## Viking CCS Pipeline

# 9.47 Applicants Responses to Issue Specific Hearing (ISH) 3 held 17 July 2024

Document Reference: EN070008/EXAM/9.47

Drawing title
**LOUTH ROAD
BLOCK VALVE STATION
(BVS3)
Regulation 5.2 (o)
Application Document Reference 4.16
(Sheet 1 of 1)**

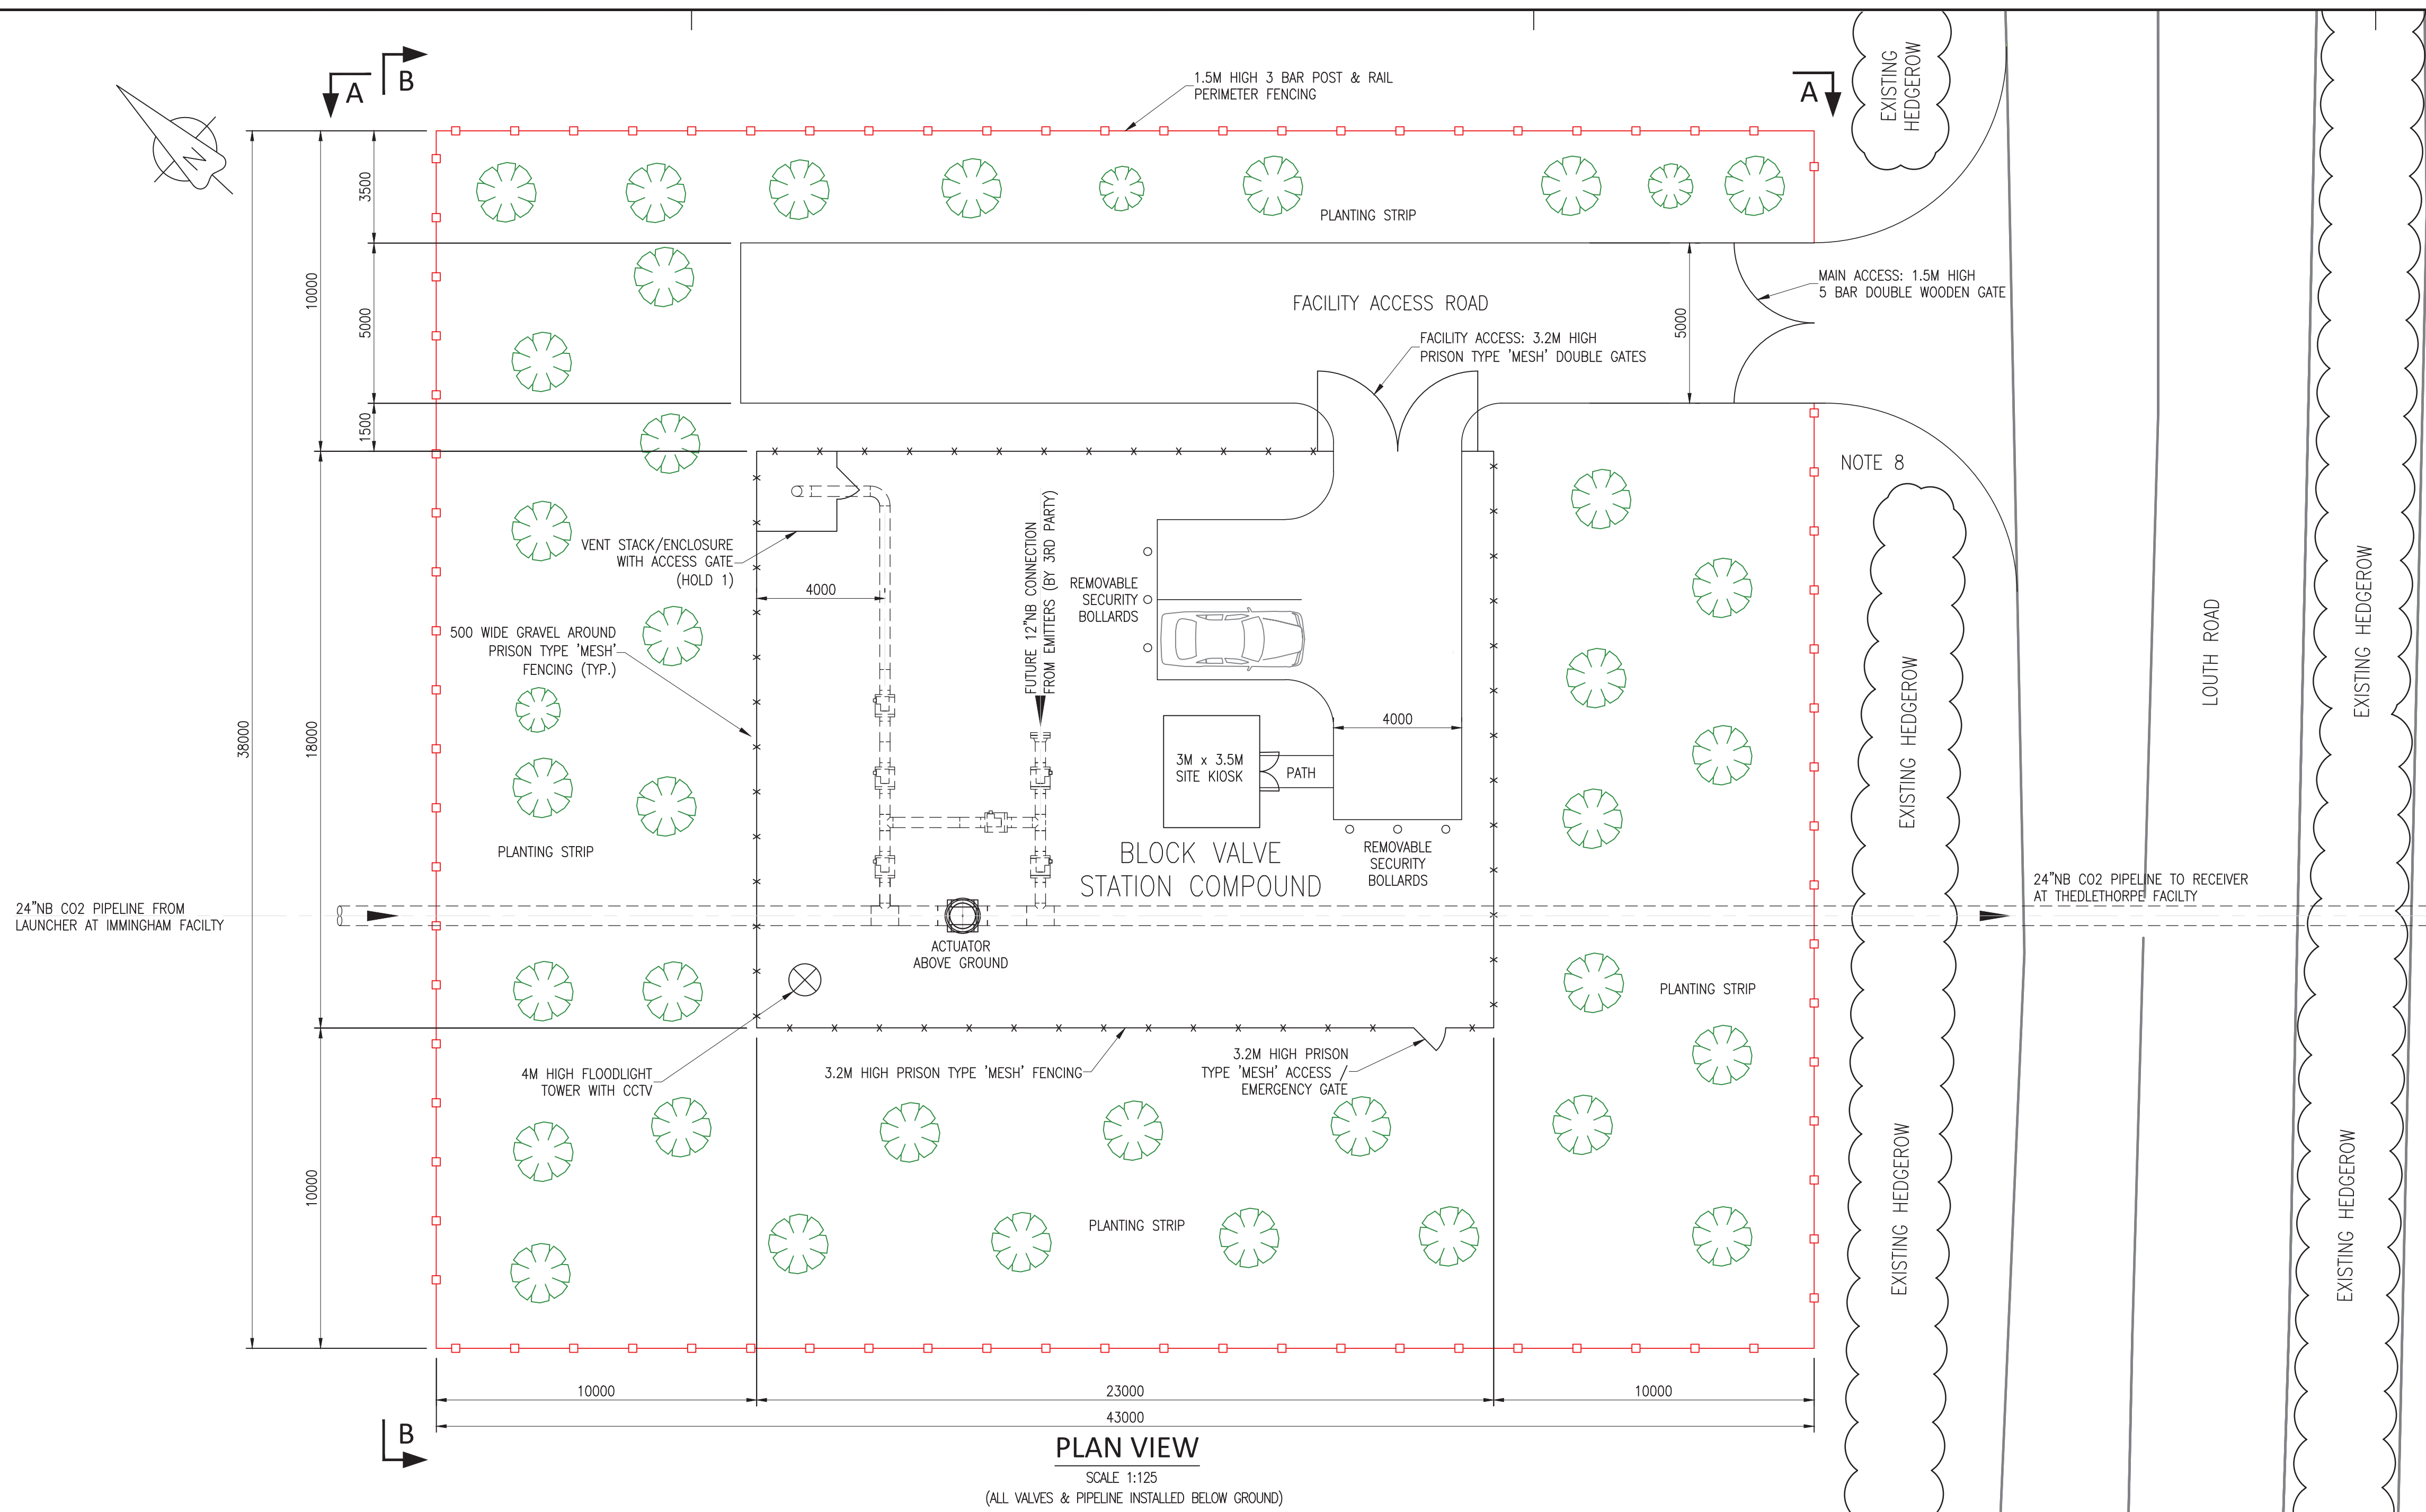
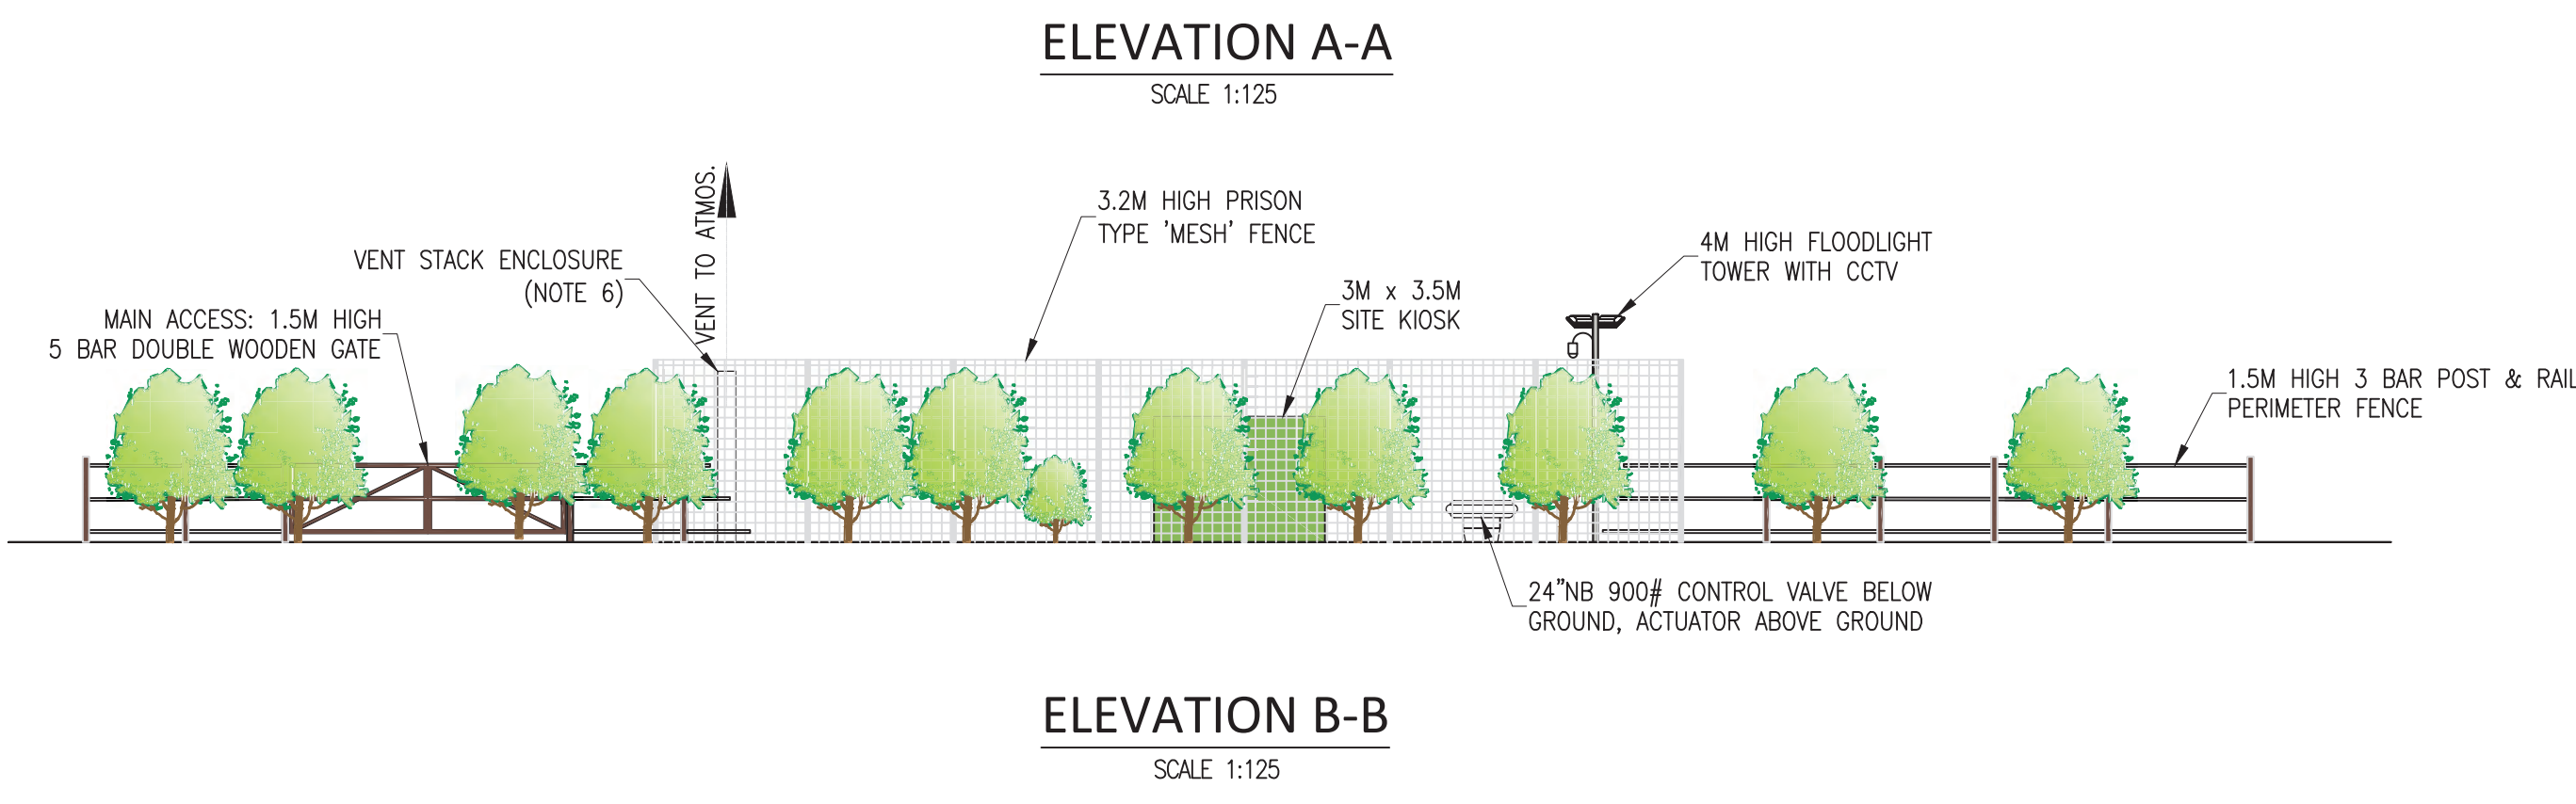
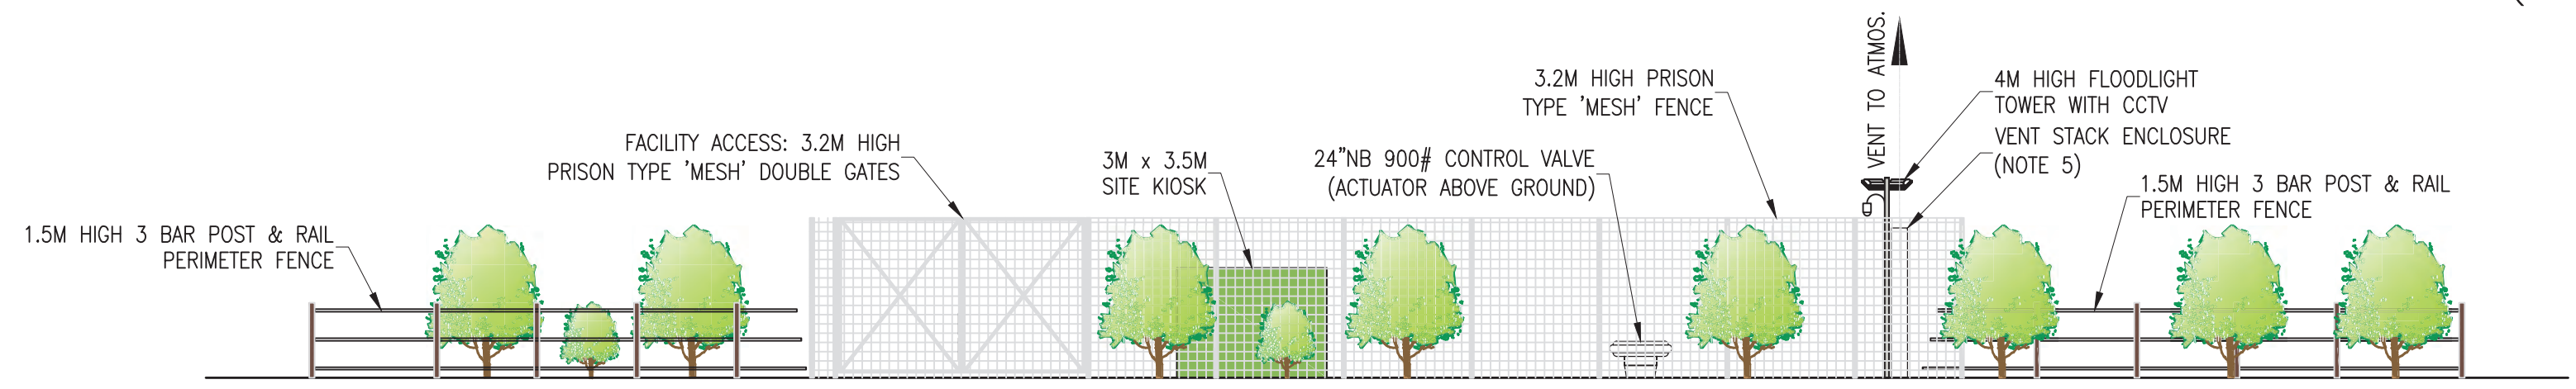
Action Ref.	Applicant Actions Raised in ISH3 17 <sup>th</sup> July 2024	Applicant's Response
13.	Provide updated illustrative plans to be certified showing the Block Valve Stations without the venting stacks.	<p>Updated illustrative plans showing the block valve stations without venting stacks have been submitted at deadline 4:</p> <p>EN070008/APP/4.14 - Washingdales Lane Block Valve Station Plan and Elevations            EN070008/APP/4.15 - Thoroughfare Block Valve Station Plan and Elevations            EN070008/APP/4.16 - Louth Road Block Valve Station Plan and Elevations</p>
